CITY OF ALBUQUERQUE

**RE: Glendesto Subdivision
Grading & Drainage Report/Plan
Stamp 8-12-2016 (File: B18D020)**

Based upon the information provided in your submittal received 8-15-2016, the above referenced Grading & Drainage Plan and Report is approved for Preliminary Plat and Grading Permit with the following condition:

SEE SHEET 2 FOR OFF-SITE
GRADING & DRAINAGE

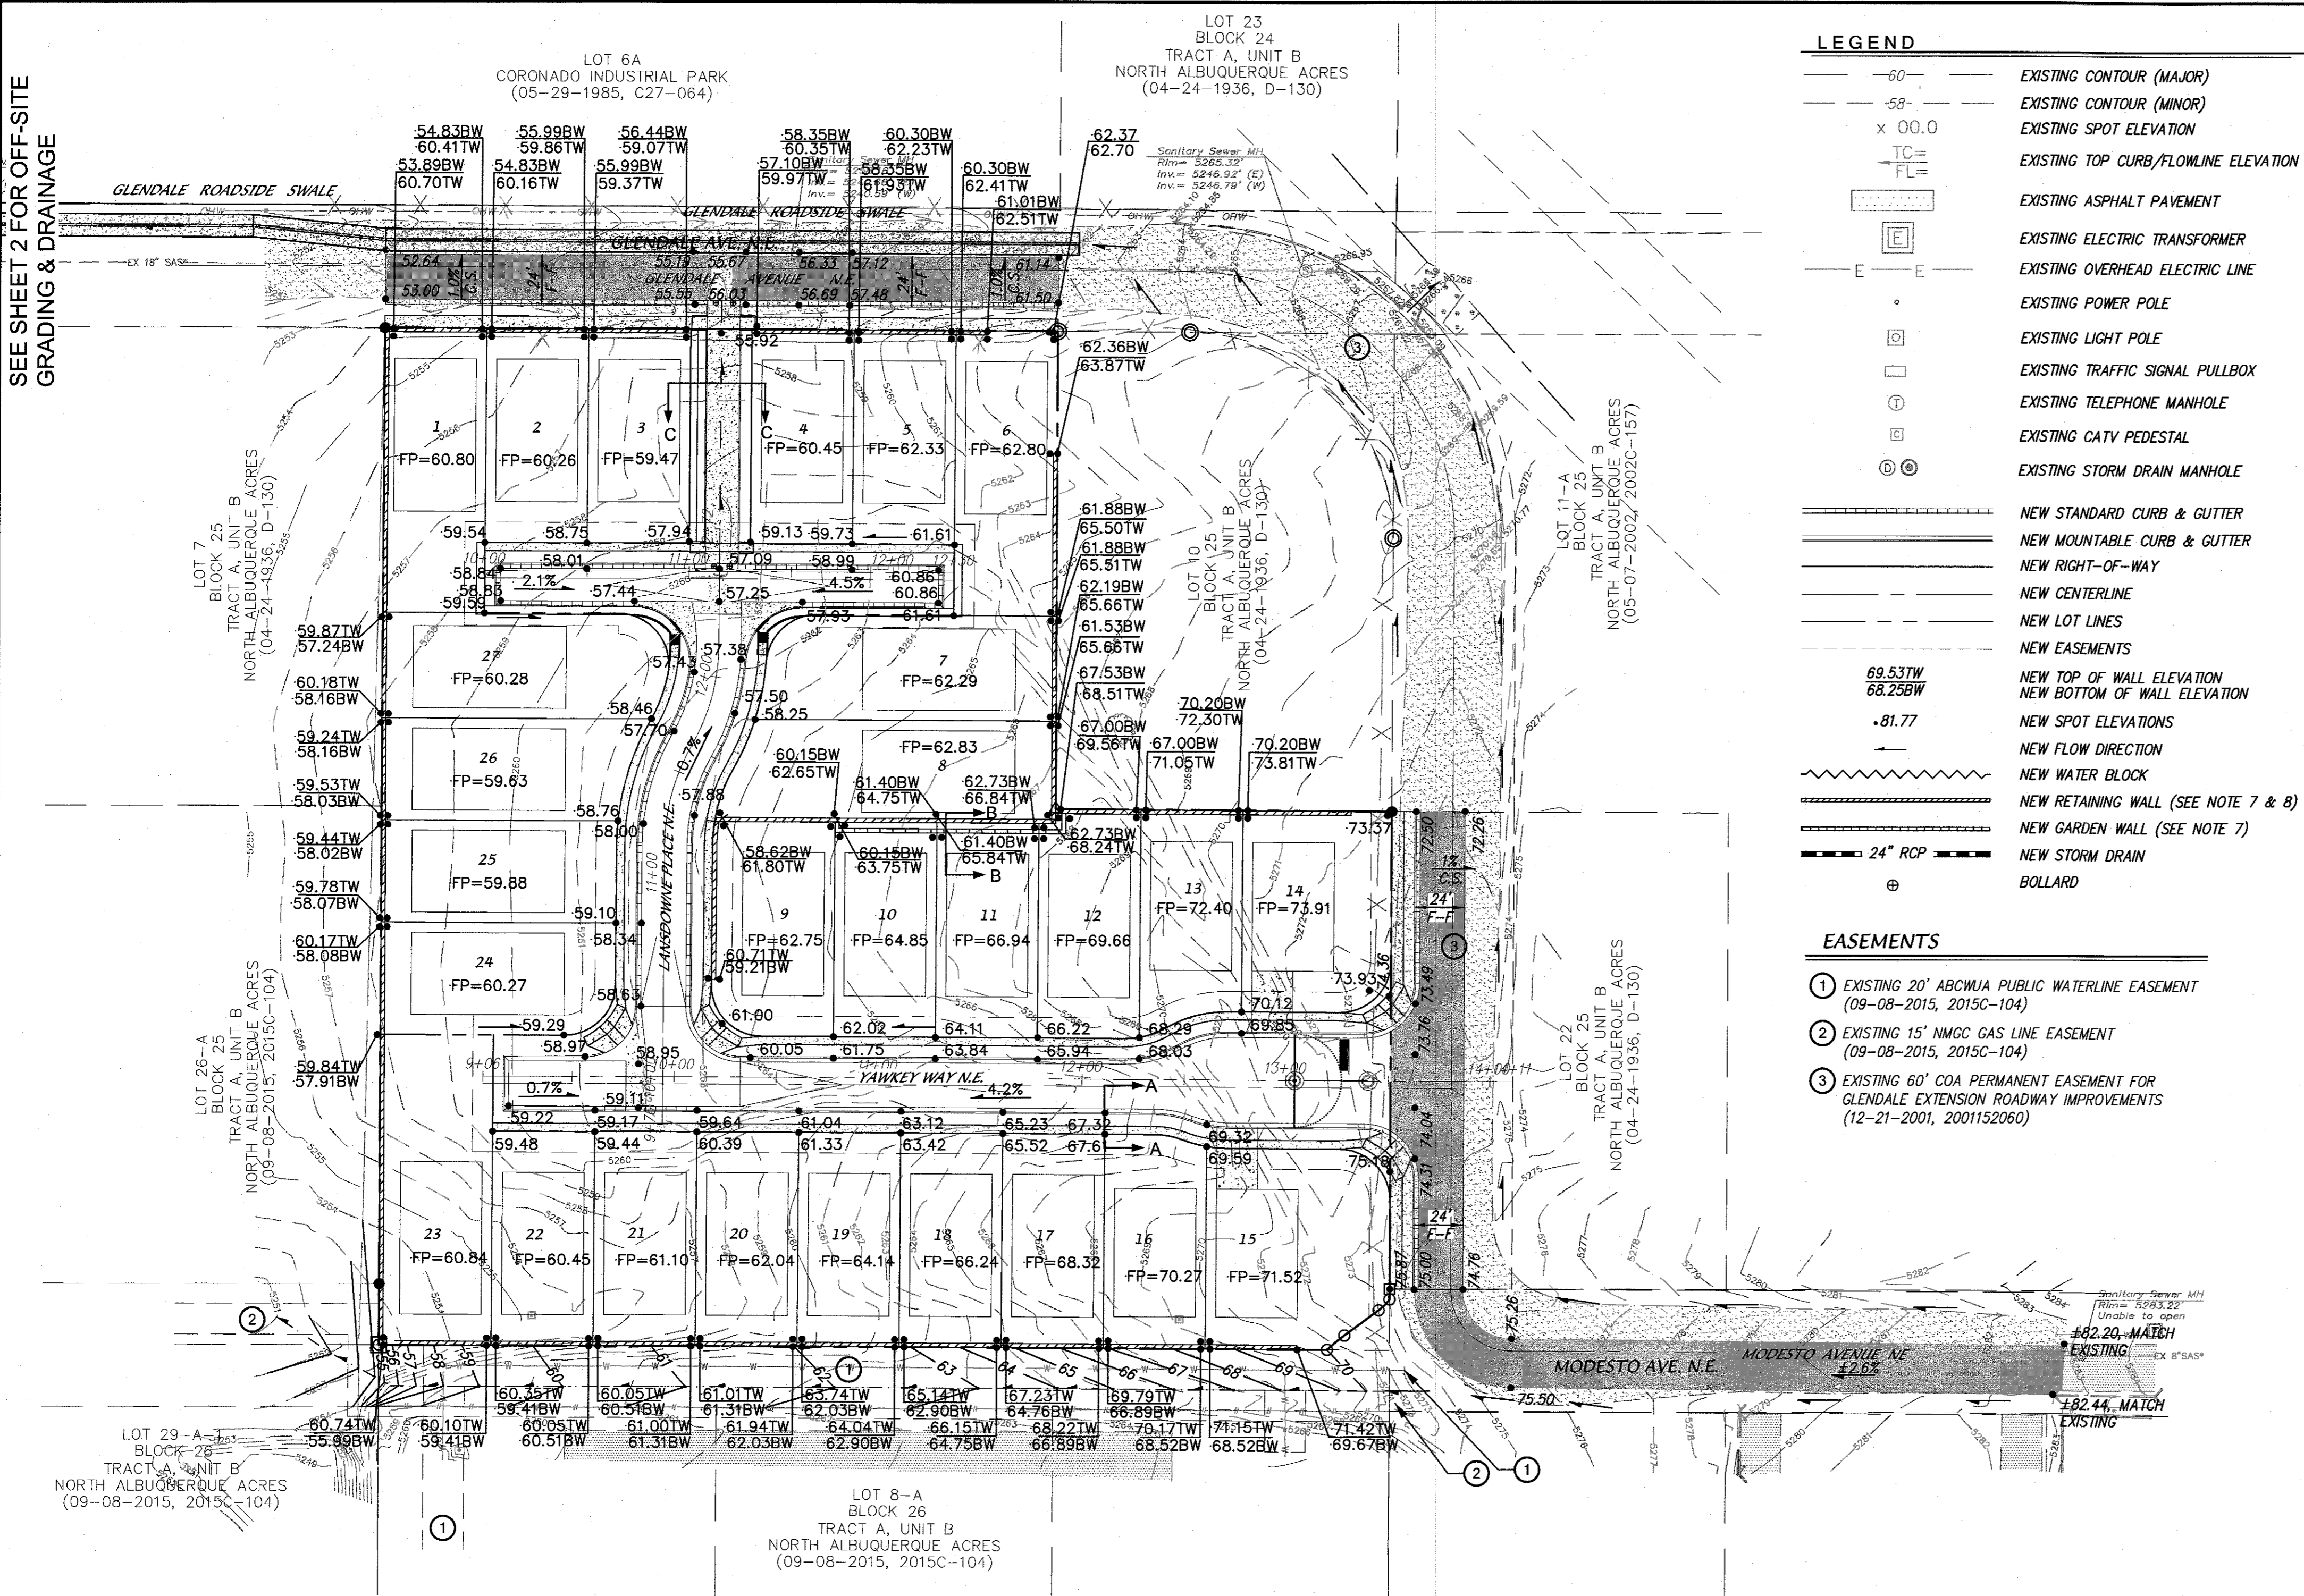
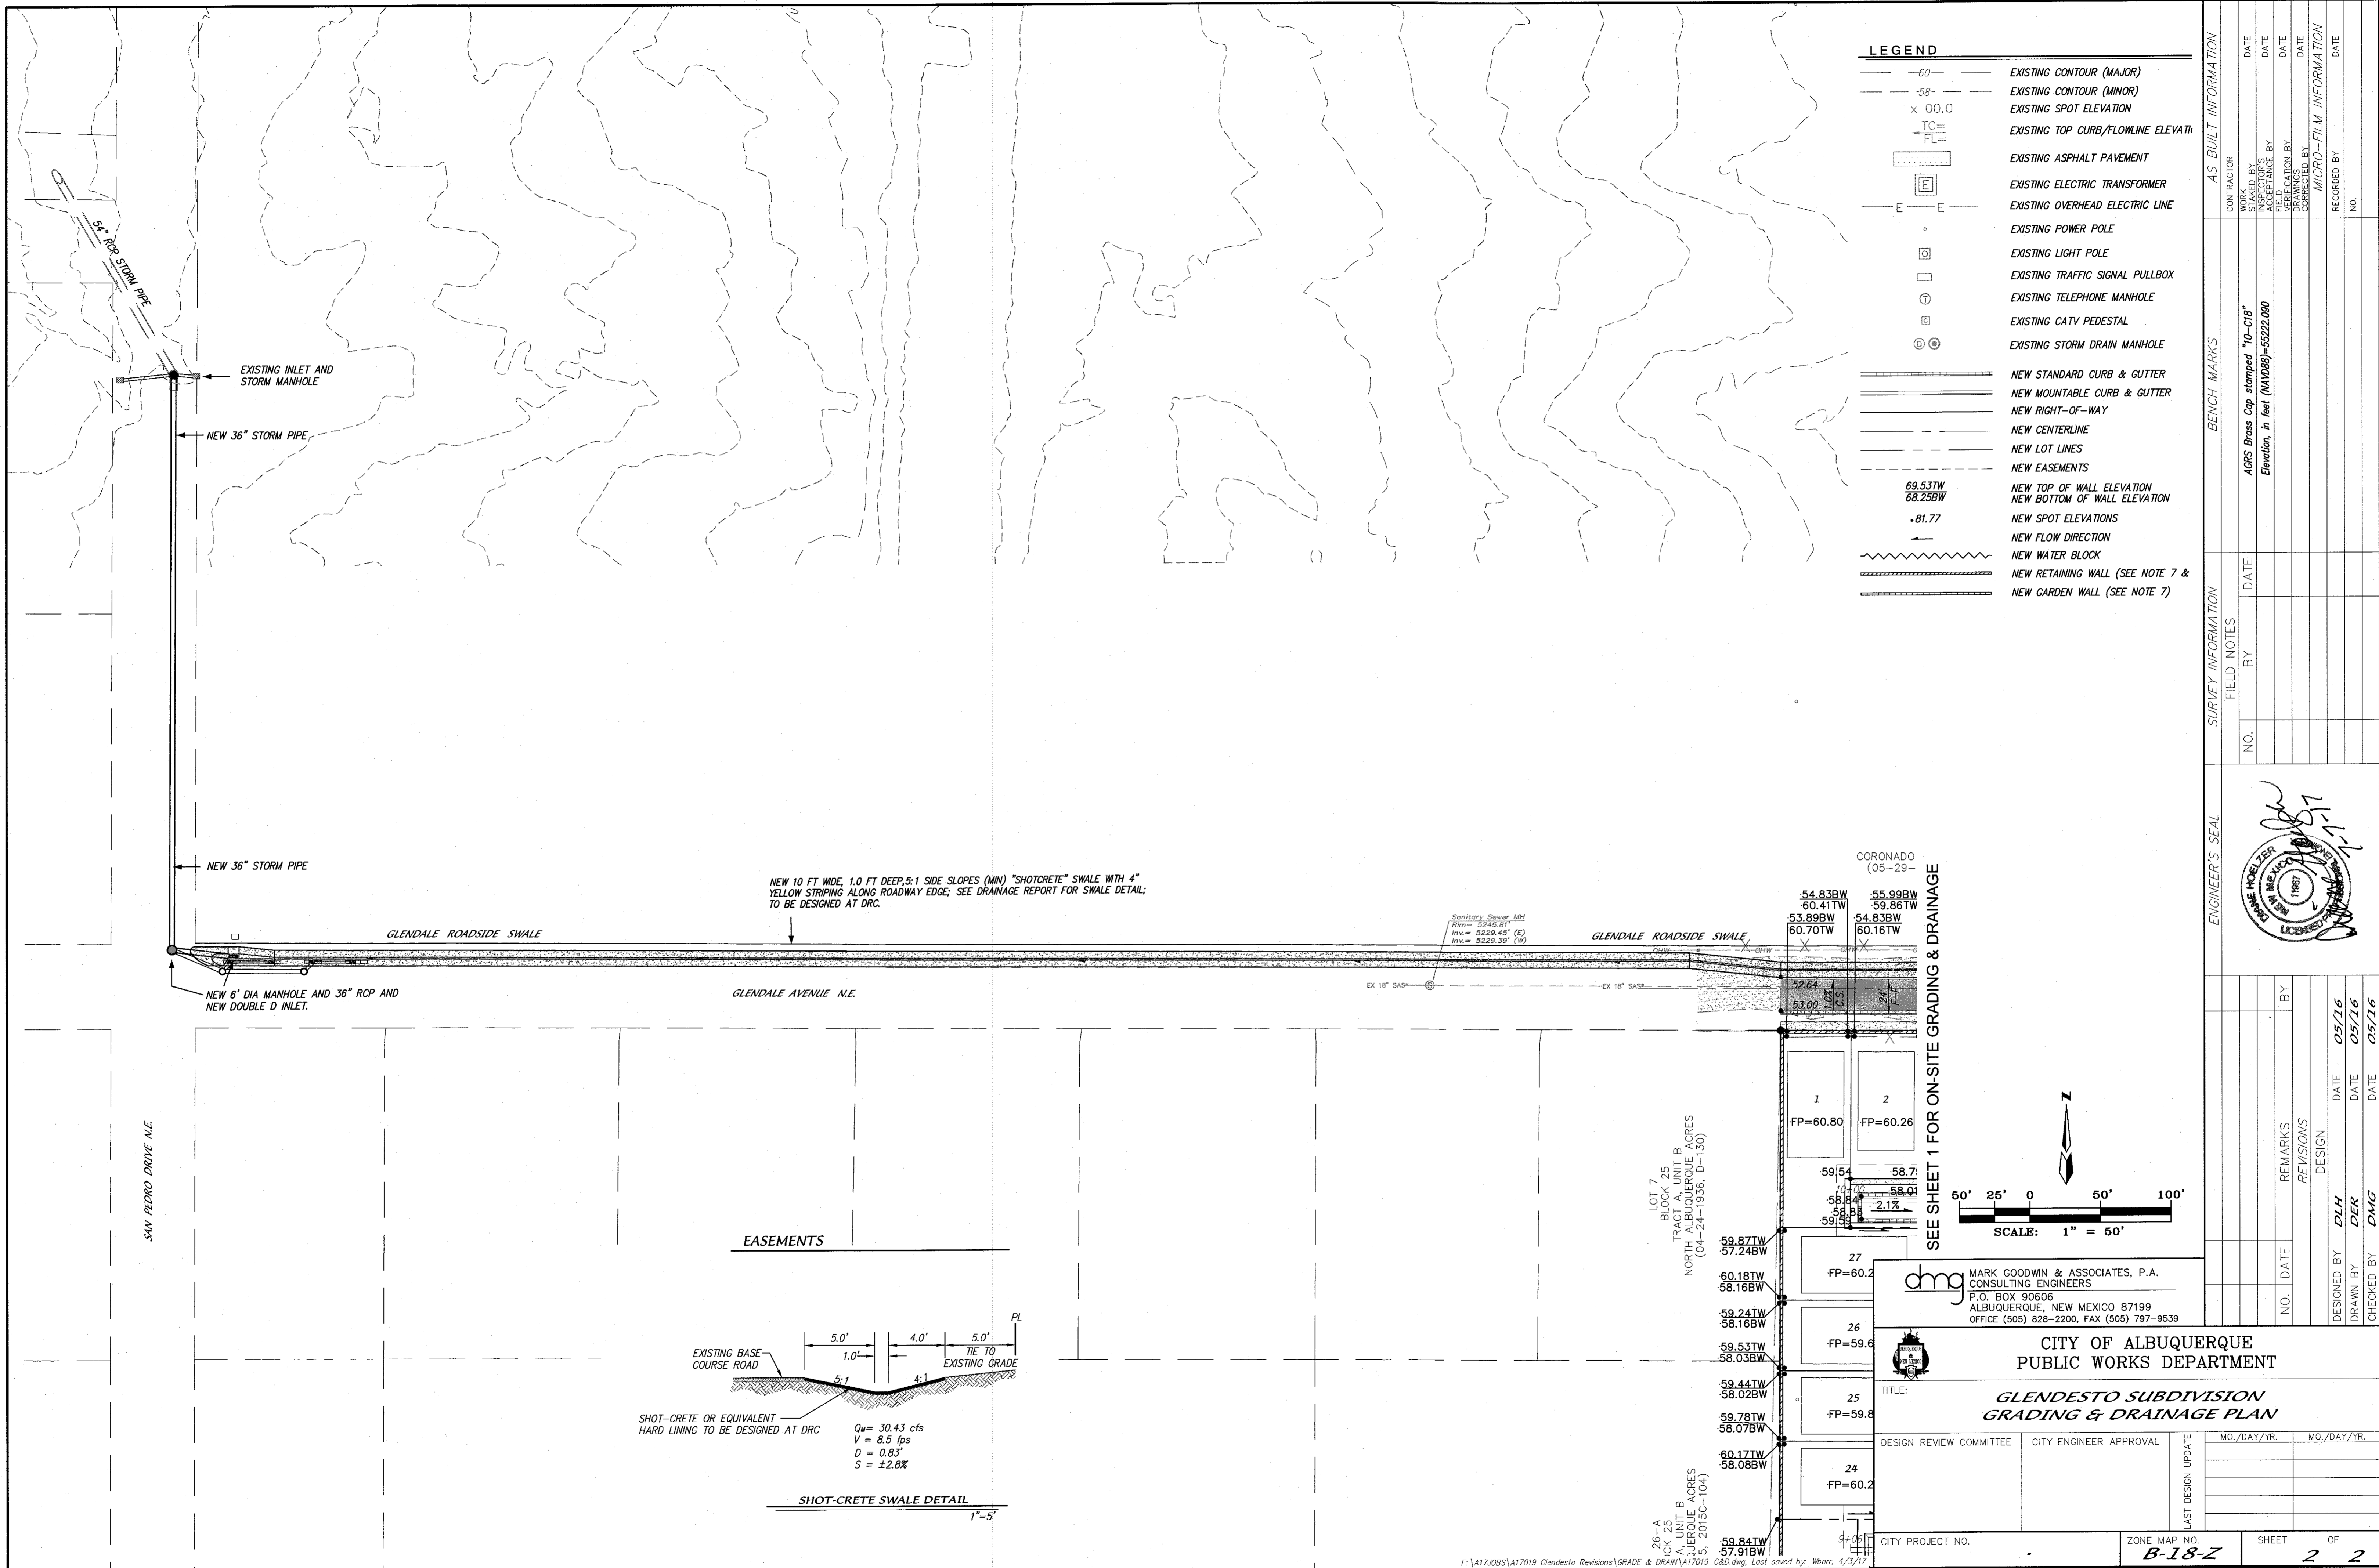
1. A valley gutter will be needed across Glendale Avenue for the outlet of surface flows from Lansdowne Ave. as a condition of Work Order approval.
